SECTION 27 AND 34, IN TOWNSHIP 12 SOUTH, RANGE 65 WEST OF
THE 6TH PRINCIPAL MERIDIAN, EL PASO COUNTY, COLORADO
RS-5000 REZONE

SMOKE STACK AT STERLING RANCH REZONE

REZONE EXHIBIT

V1_ Zone Map P2311 comment.pdf Markup Summary

REZONE EXHIBIT

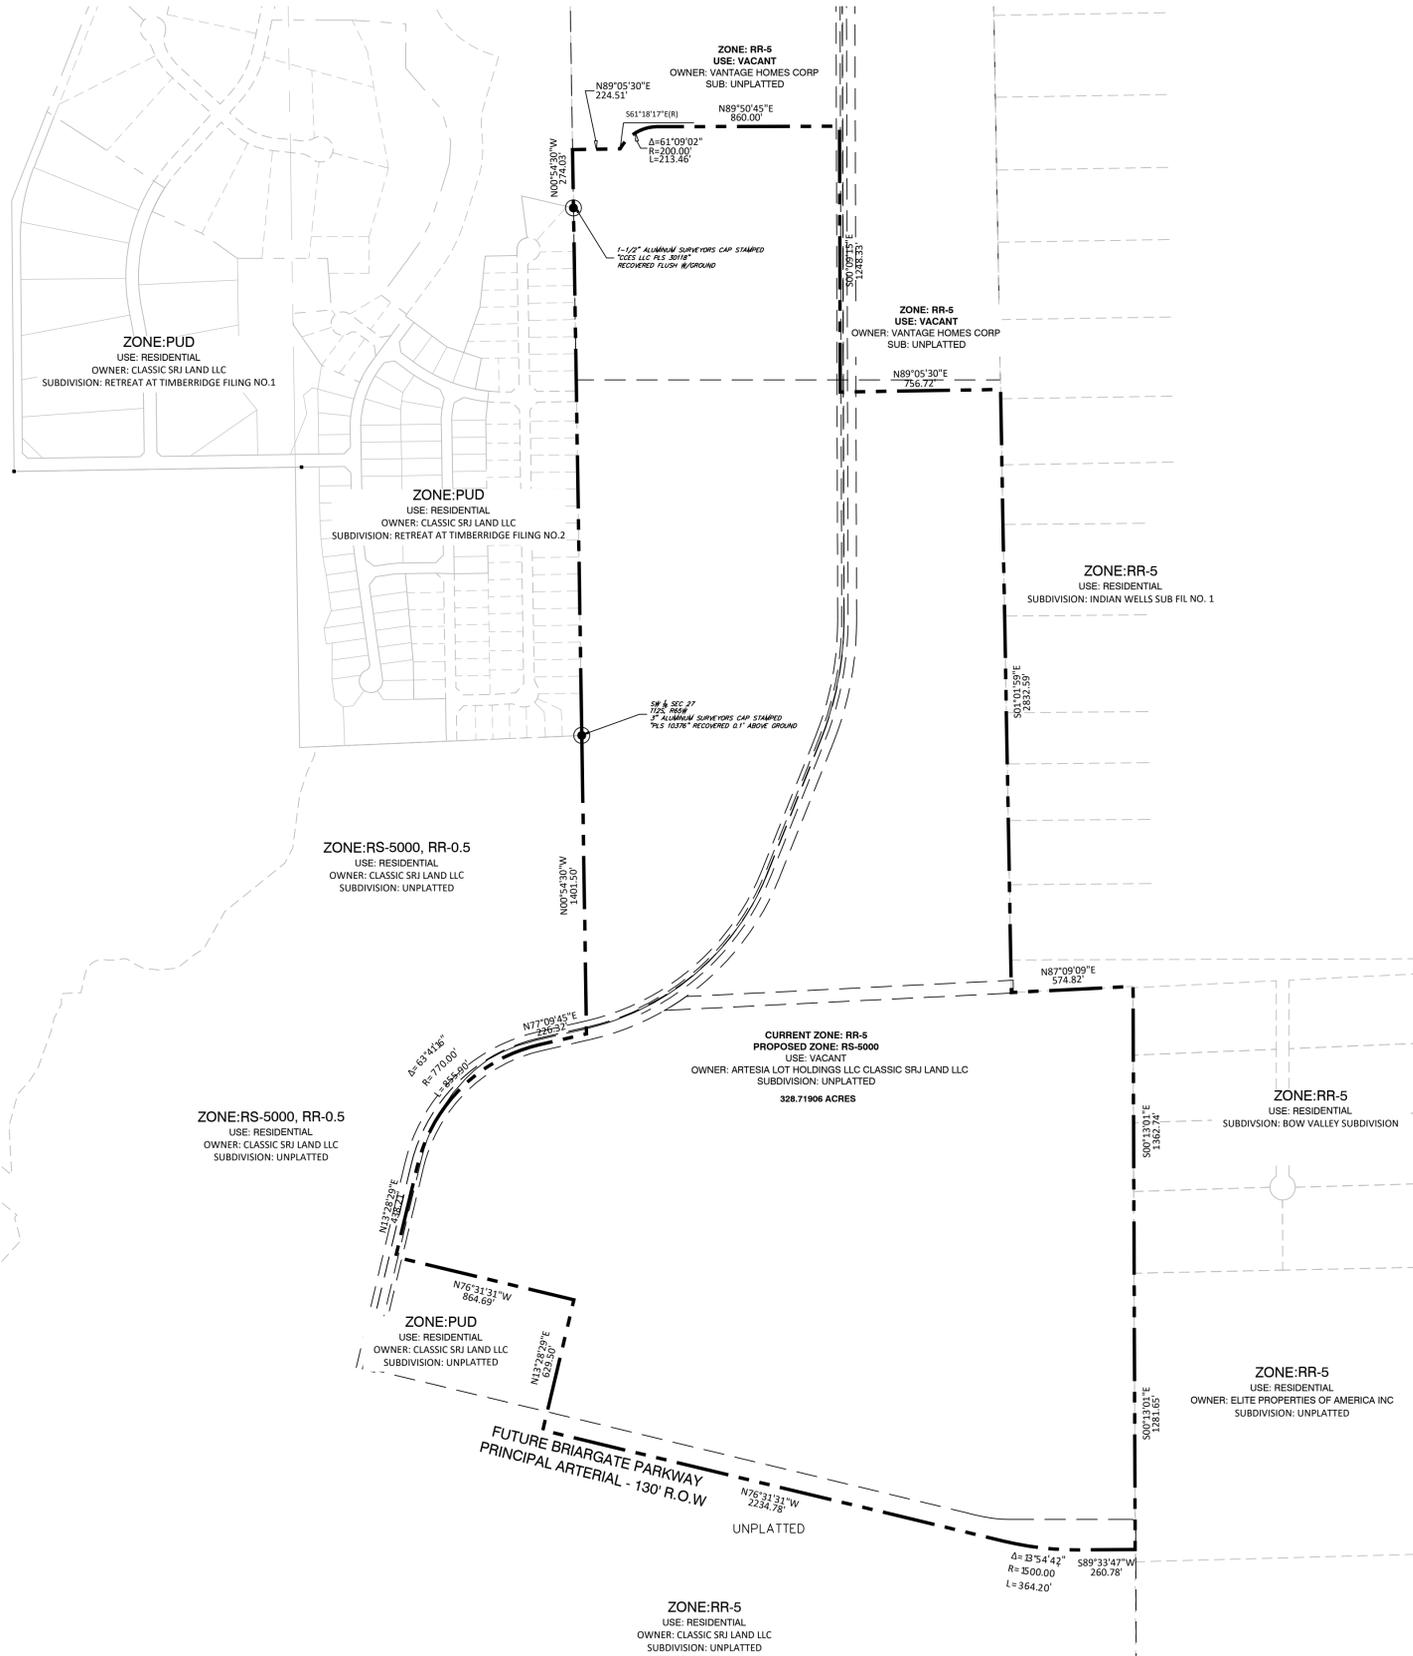
please identify subdivision names for clarity

please identify subdivision names for clarity

is this correct for the adj landuse and zoning? Is this foursquare?

EASEMENT runs to tank site; are there access easements that need to be depicted?

where is Briargate Parkway in reference to this boundary?

provide acreage
